Advice to decision maker on coal mining project

IESC 2023-140: Moolarben Coal Complex OC3 Extension (EPBC 2022/9162 and SSD 33083358) – Expansion

Requesting agency	The Australian Government Department of Climate Change, Energy, the Environment and Water and the New South Wales Department of Planning and Environment
Date of request	14 December 2022
Date request accepted	21 December 2022
Advice stage	Assessment

Estimated Palaeochannel Drawdown

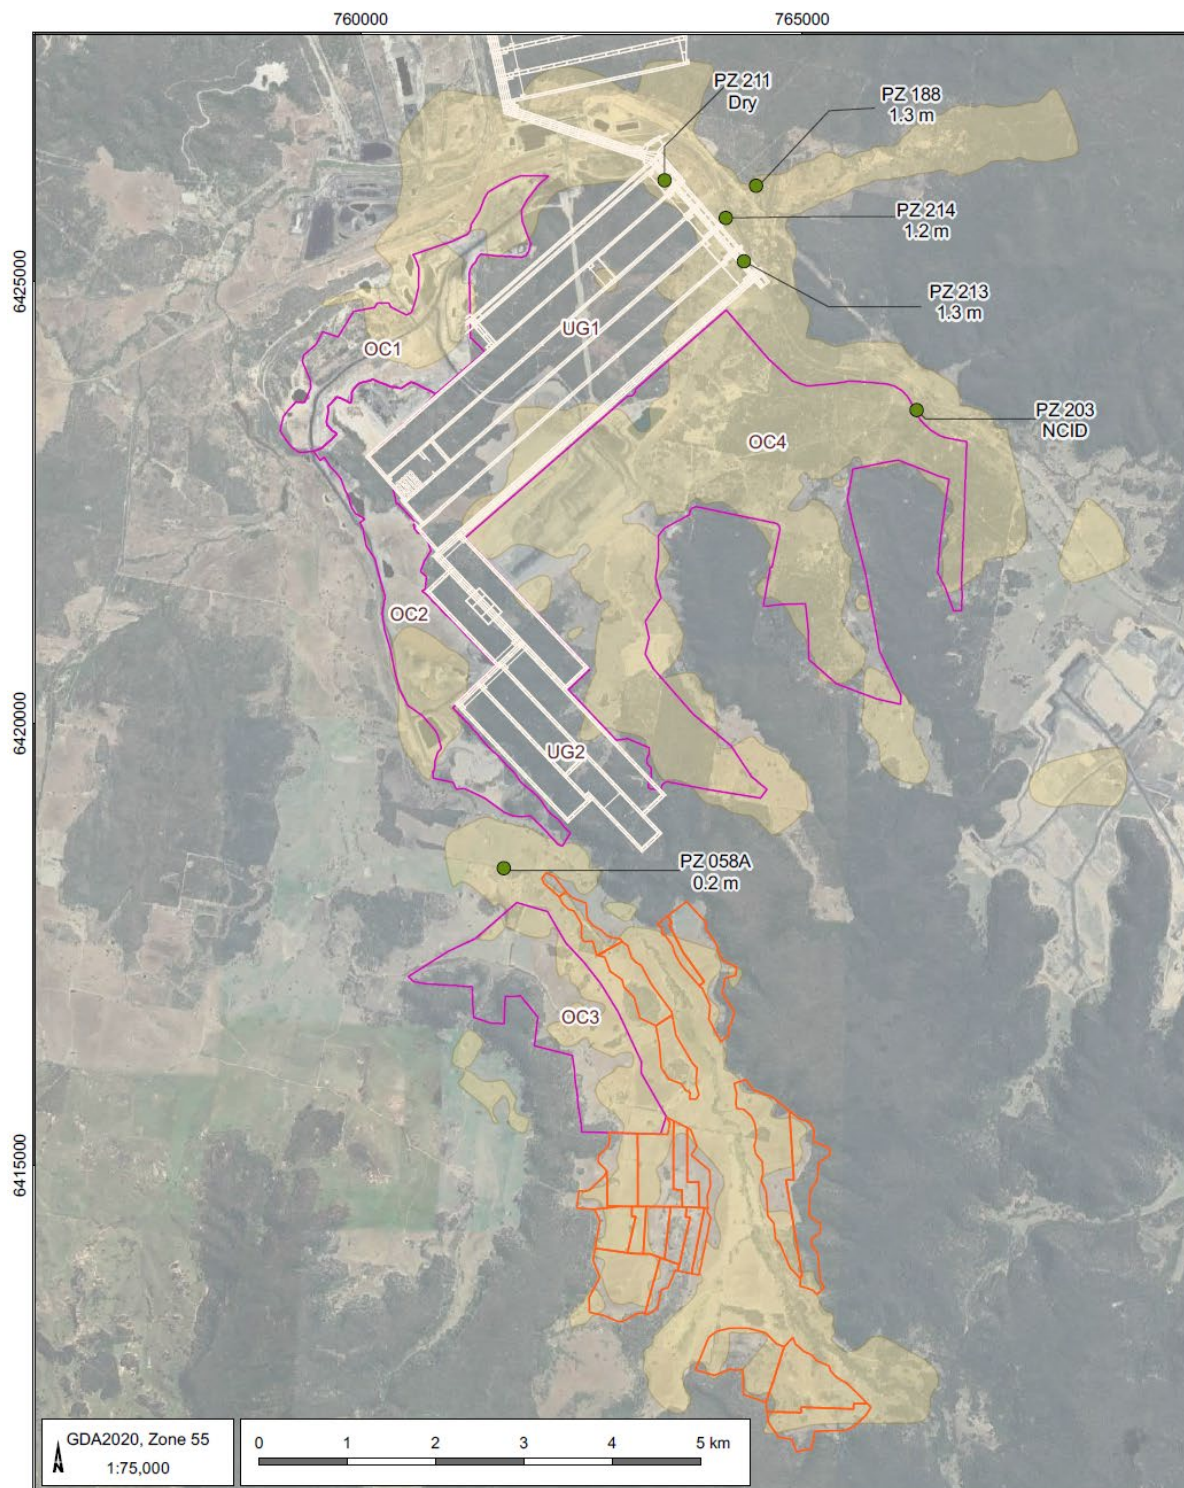
- a. The proponent states that interpretation of geophysical survey data indicates that the maximum thickness of the Tertiary palaeochannel sediments is approximately 30 metres (AGE 2022, p. 82); however, this is not clearly supported by the information provided. The proponent should clarify how the Tertiary palaeochannel sediments have been delineated as their representation in the groundwater model may affect predictions of drawdown in overlying unconsolidated sediments that could support GDEs. Similarly, the extent, thickness and degree of saturation of the alluvium present along Moolarben Creek and its geometry in relation to the proposed mine extension require clarification.

FIGURE No:
2.1

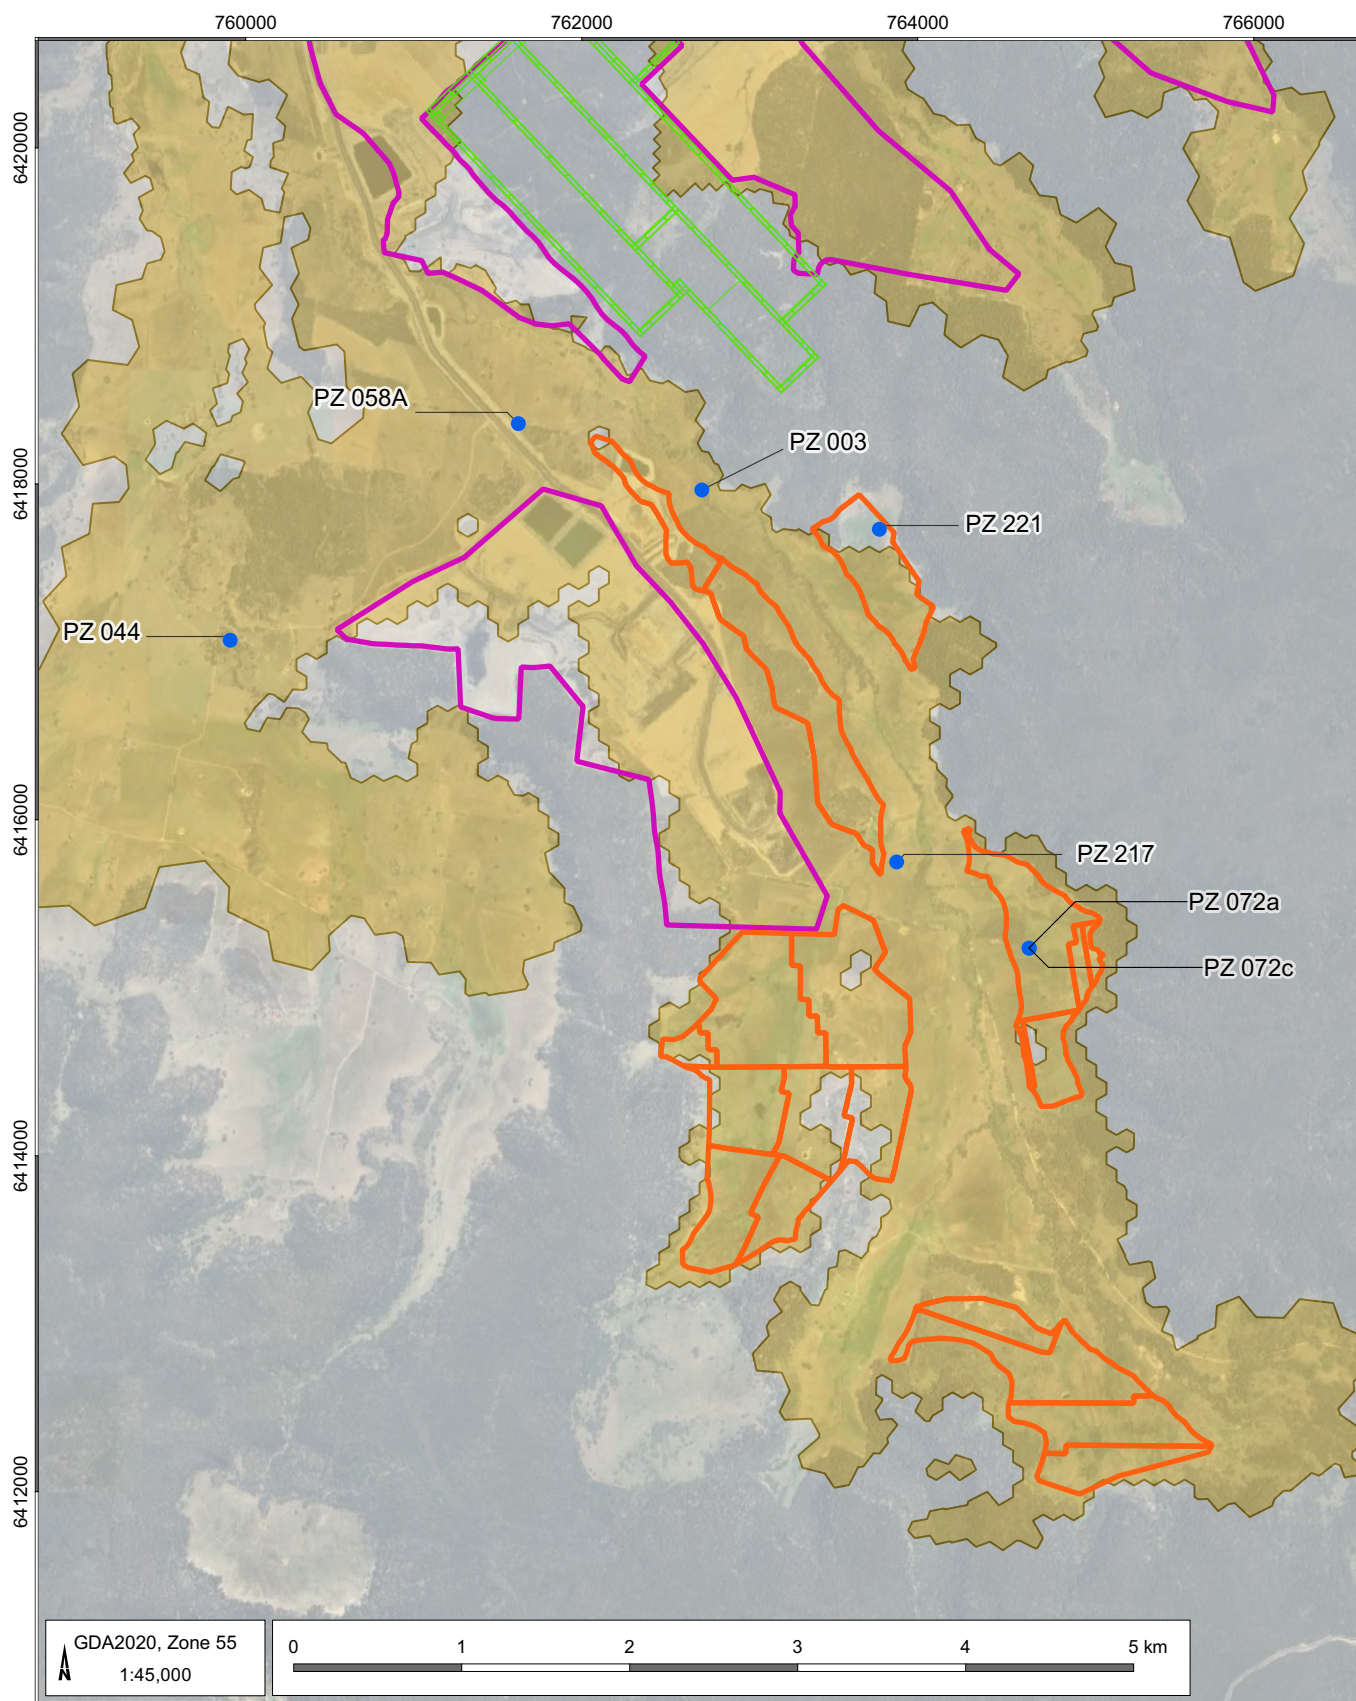
22. The IESC notes that alluvial and streamflow monitoring on Moolarben Creek is extremely limited and provides little indication of flow regimes upstream of the present OC3 operations. Additional alluvial monitoring bores and flow monitoring sites should be placed upstream of the confluence with Lagoon Creek and within the project area downstream of the Murdering Creek confluence. Two years of continuous baseline monitoring data should be obtained to develop a comprehensive understanding of the alluvial system and flow patterns such that impacts to Moolarben Creek can be identified and assessed at the local scale, and suitable management plans developed to remediate impacts.

ATTACHMENT 6 – SURFACE WATER MONITORING SITES

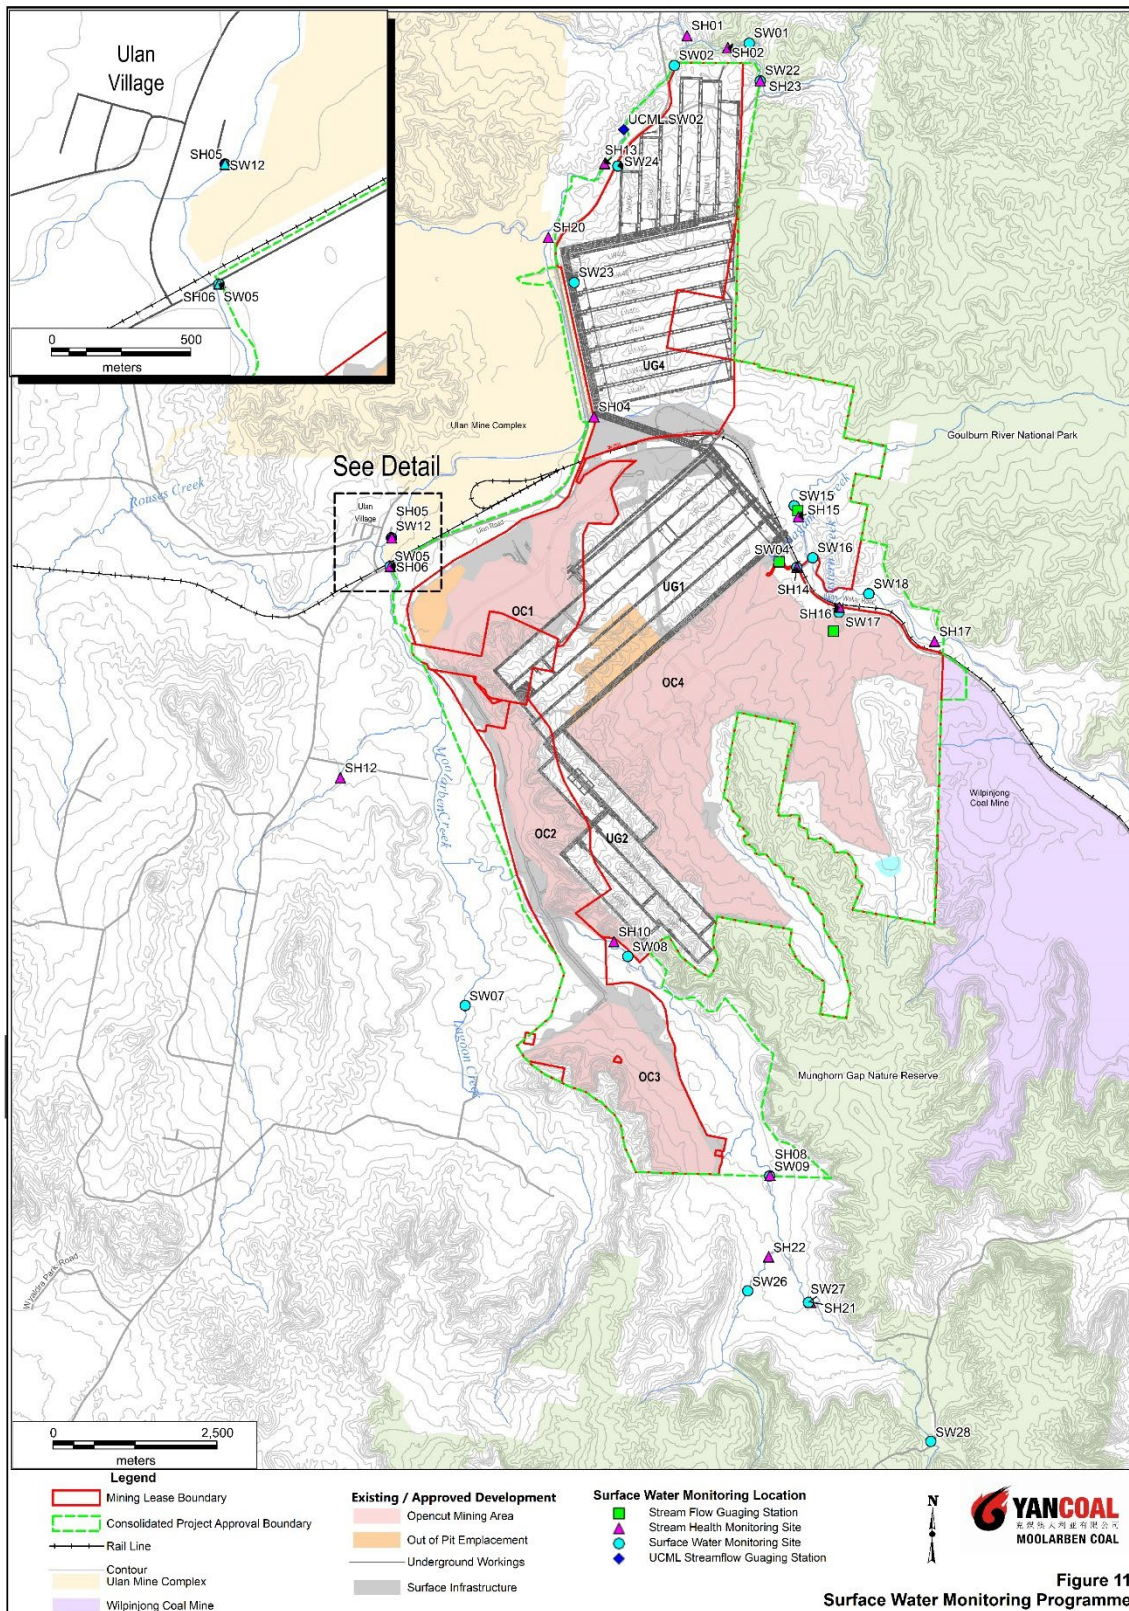
23. The existing water quality monitoring site SW09 will be relocated further upstream of Moolarben Creek as mining progresses (WRM 2022, p. 100). Relocating the monitoring site will prevent the proponent from assessing changes to water quality resulting from the project as there will likely be insufficient pre-impact baseline data available at the new location. To address this, additional water

quality monitoring sites should be established further upstream on Moolarben Creek instead of the proposed relocation.

Figure 1: Conceptual Hydrogeological Cross-section Locations (Source: AGE, 2025)

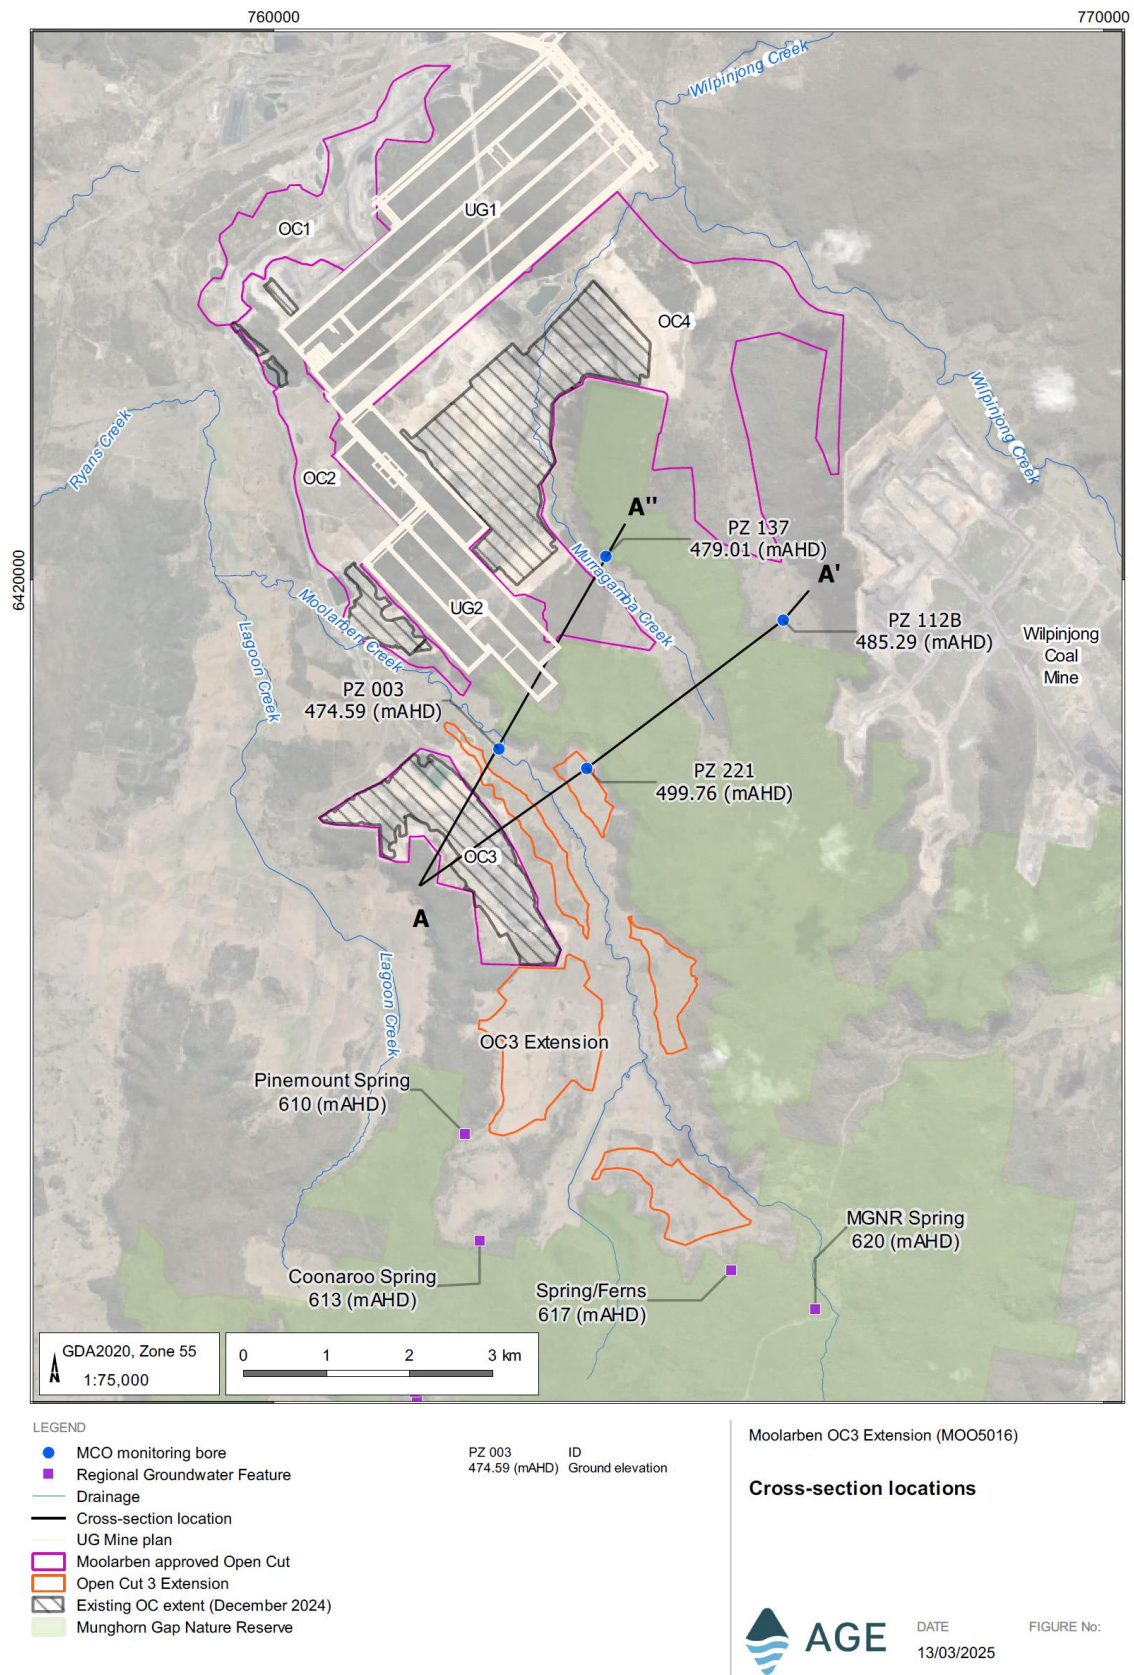
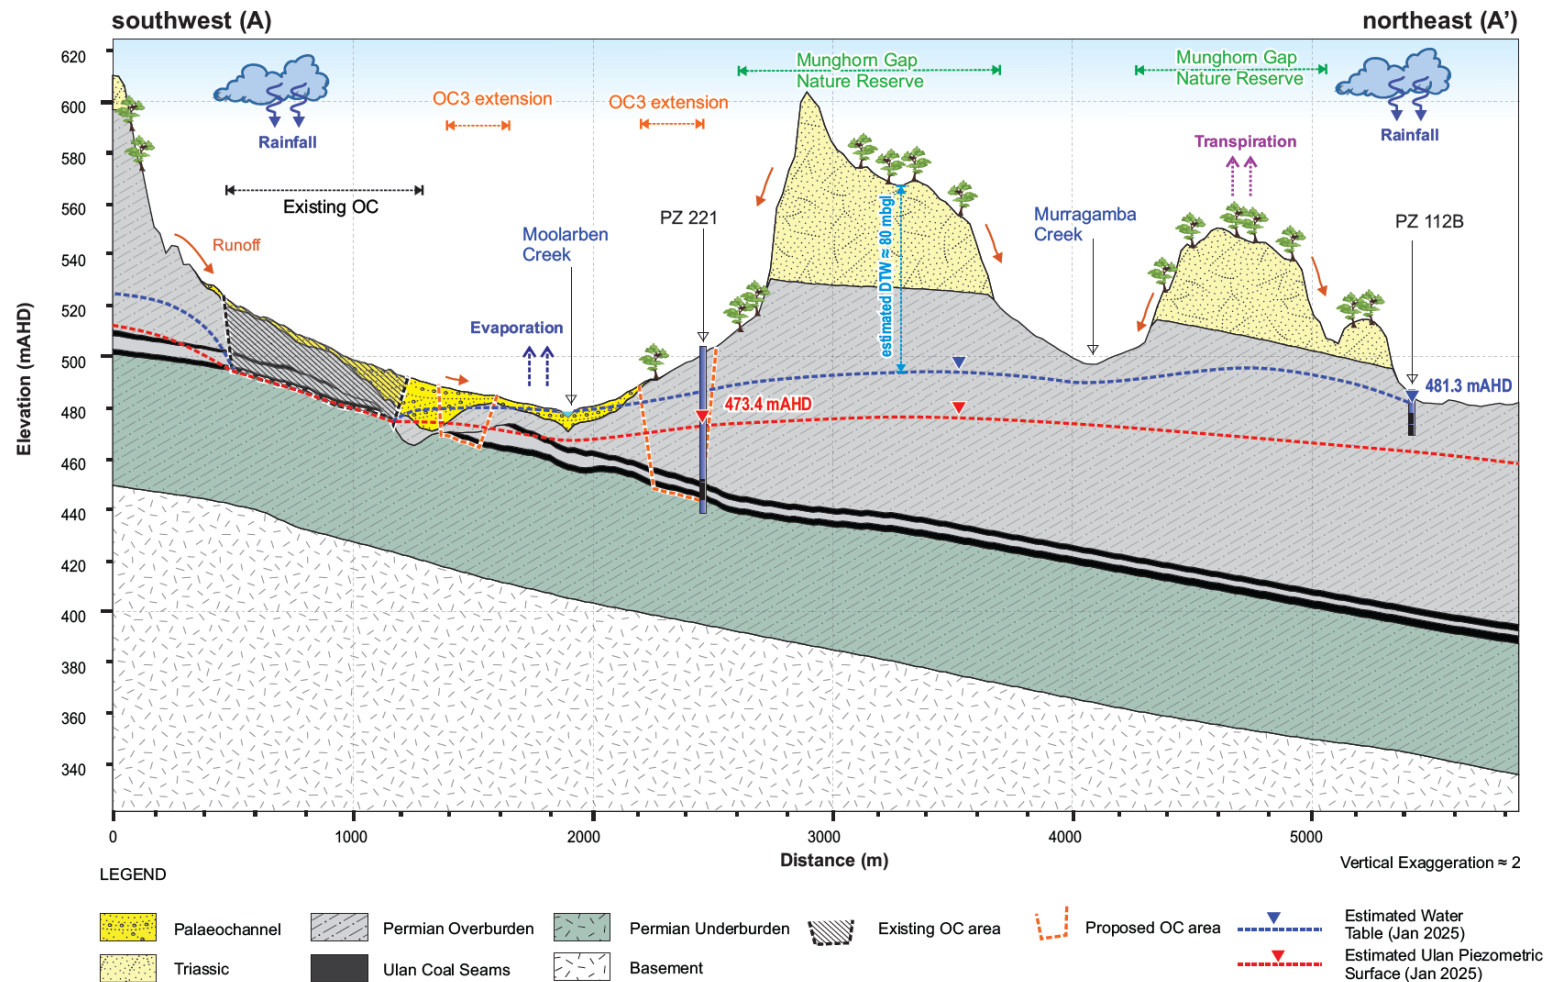
2. Modelling should ideally have included an ecohydrological conceptual model (ECM) to support identification of potential impact pathways from proposed activities to water-dependent assets. Two large-scale hydrogeological cross-sections have been supplied, but these do not adequately capture the complexity of ecohydrological relationships nor potential impacts to water-dependent biota, particularly those using surface water. An ECM should be developed and used to derive an appropriate geo-referenced impact pathway diagram that indicates the probable extent and magnitude of the project's impacts. The conceptual models should be sufficiently detailed to identify impacts to specific resources (e.g., individual groundwater-fed pools), and should be used to guide risk assessment and focus mitigation and monitoring strategies.
